Item No. **Report of the Head of Planning, Transportation and Regeneration**

Address LAND ADJ. TO 33 HAZELWOOD DRIVE PINNER

Development: Erection of a single storey 2 bed house with associated parking and amenity space

LBH Ref Nos: **6342/APP/2020/1947**

Number
108-210

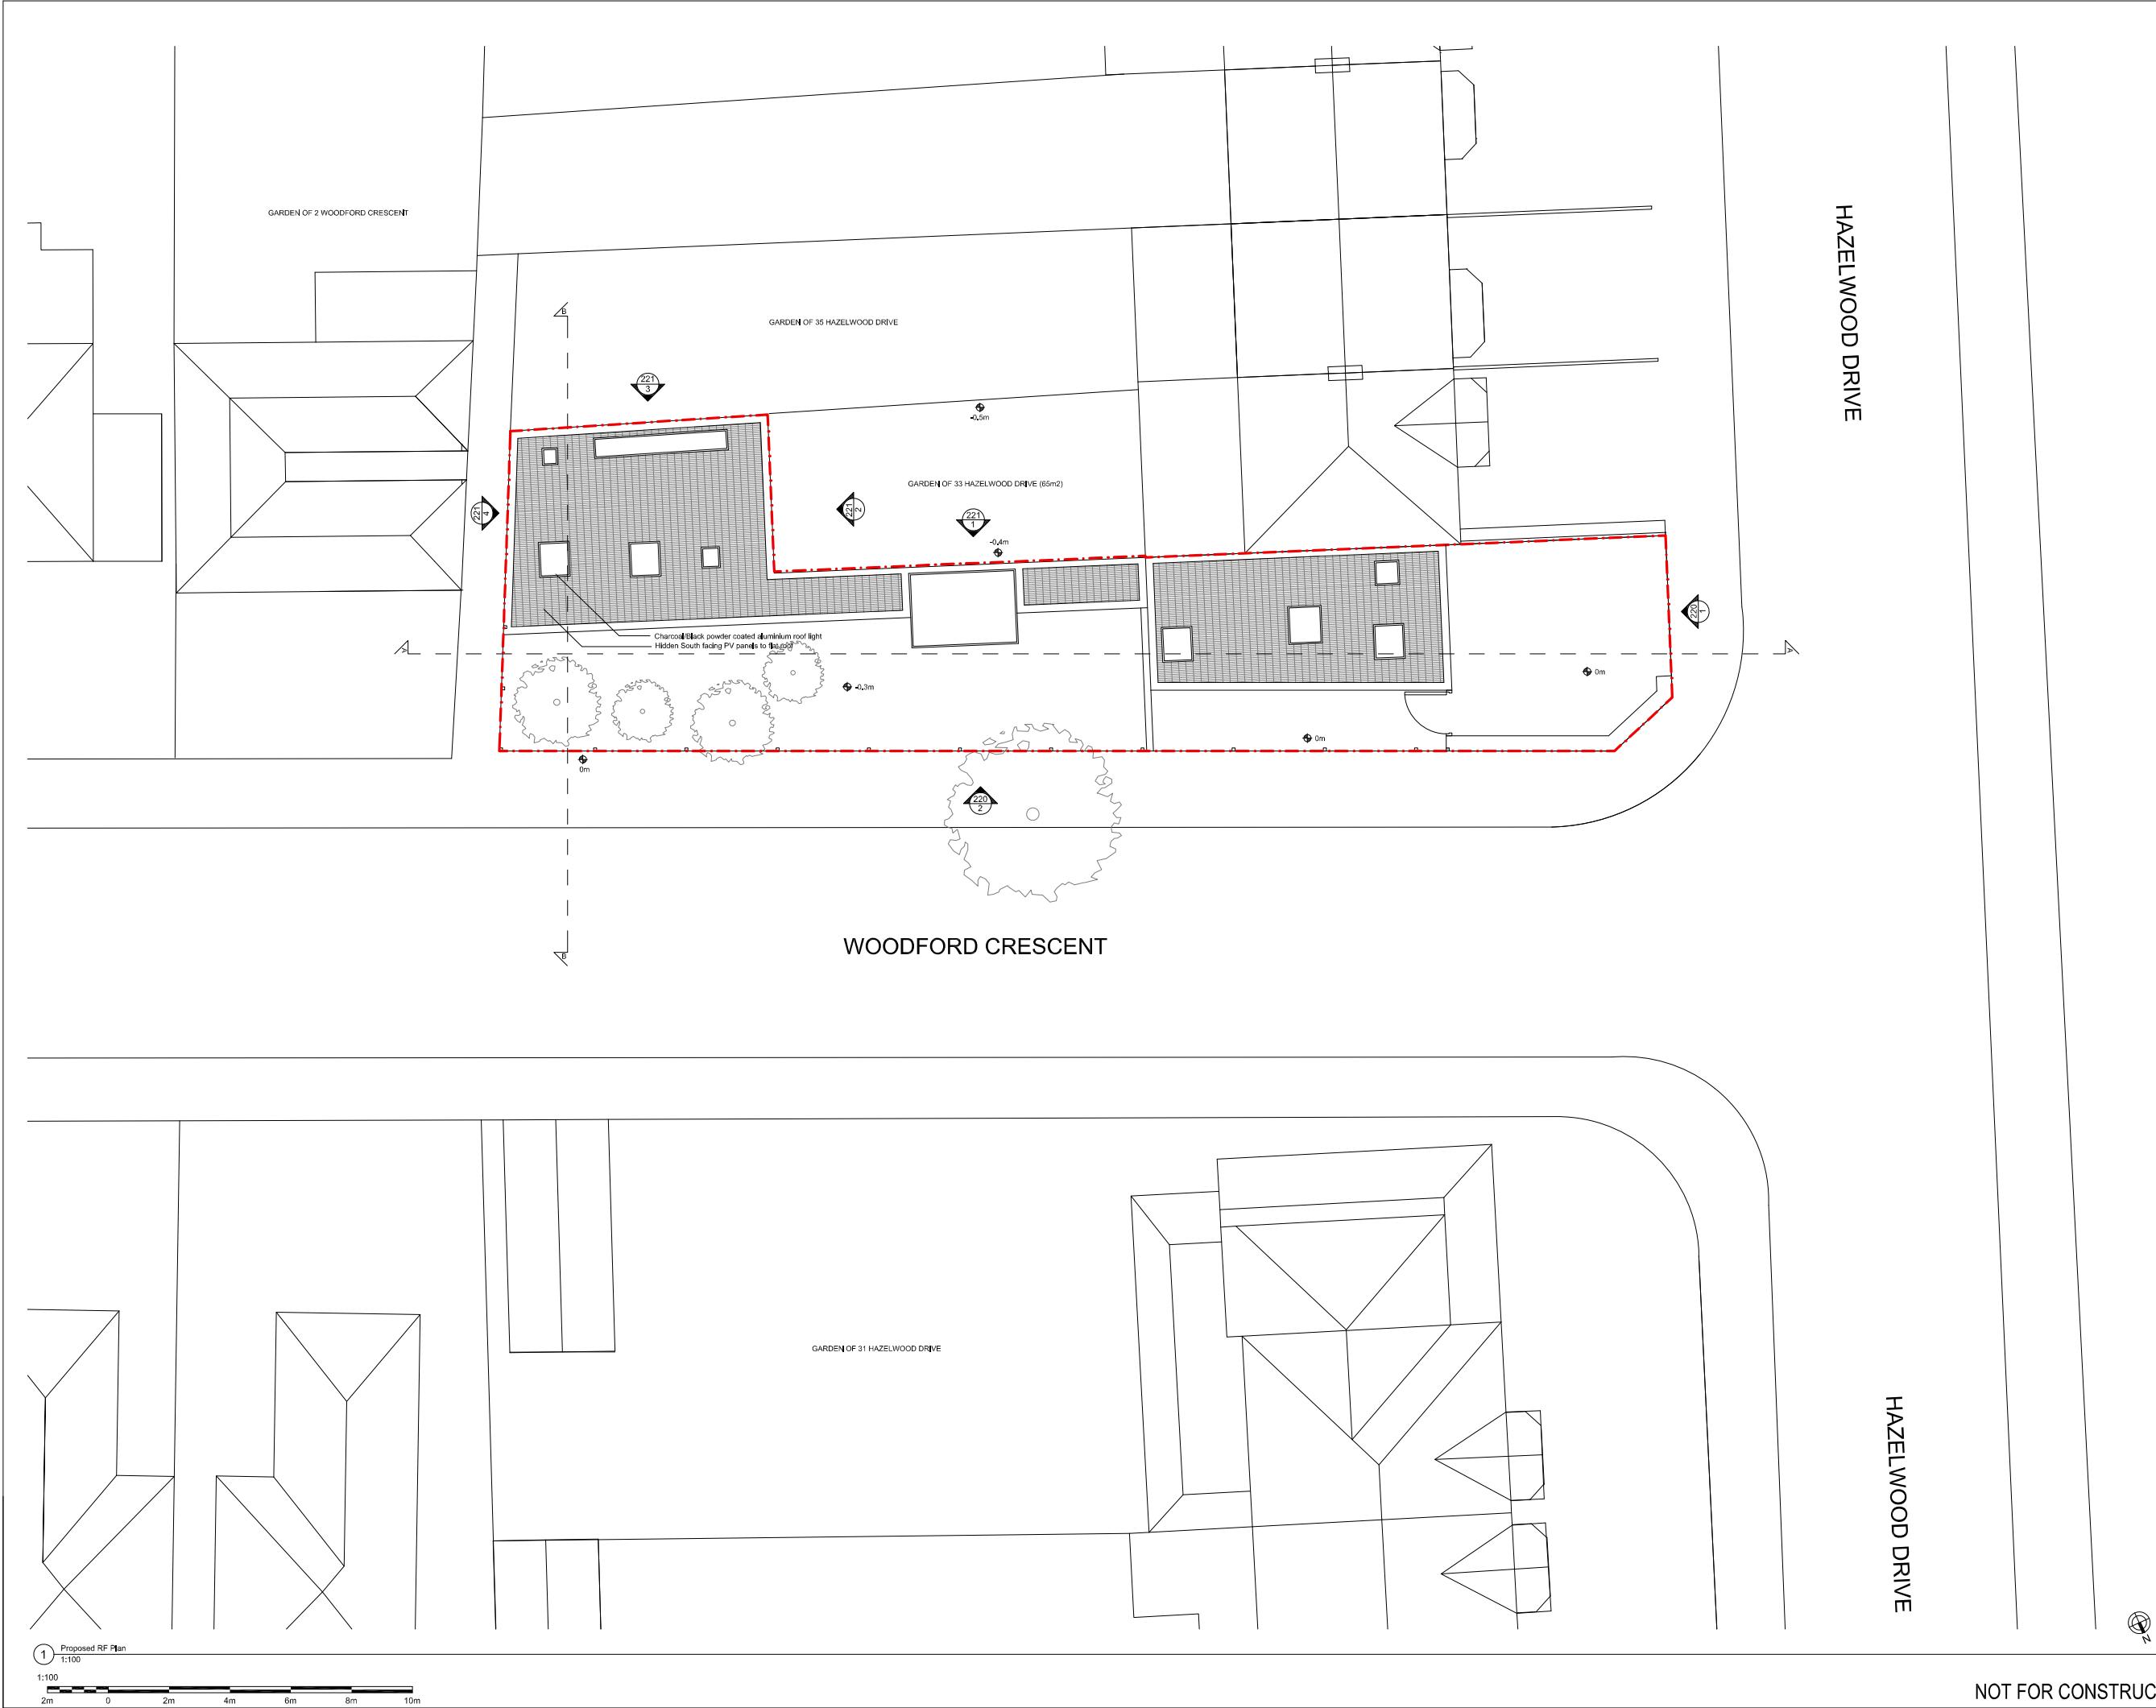
Although the internal passageways have been increased in width to 1200mm, the design still falls short of the technical standards as set out in AD-M for the following reasons:

1. The ramps shown on plan no. 108-210, dated 29/4/2020, are required to have an intermediary landing every 2 metres. The ramp flights are circa 5.5 m and 4.5 m and do feature a landing. It is deemed not possible to provide two compliant flights in the available space.
2. The main bathroom fails to comply with diagram 27 of AD-M, nor does it demonstrate how the associated clear access zones described in AD-M could be achieved.
3. Particular attention should also be paid to the entrance lobby, and to the spatial requirements within the bedrooms.

Conclusion: Unacceptable. The proposal fails to demonstrate compliance with London Plan policy 3.8 (c).
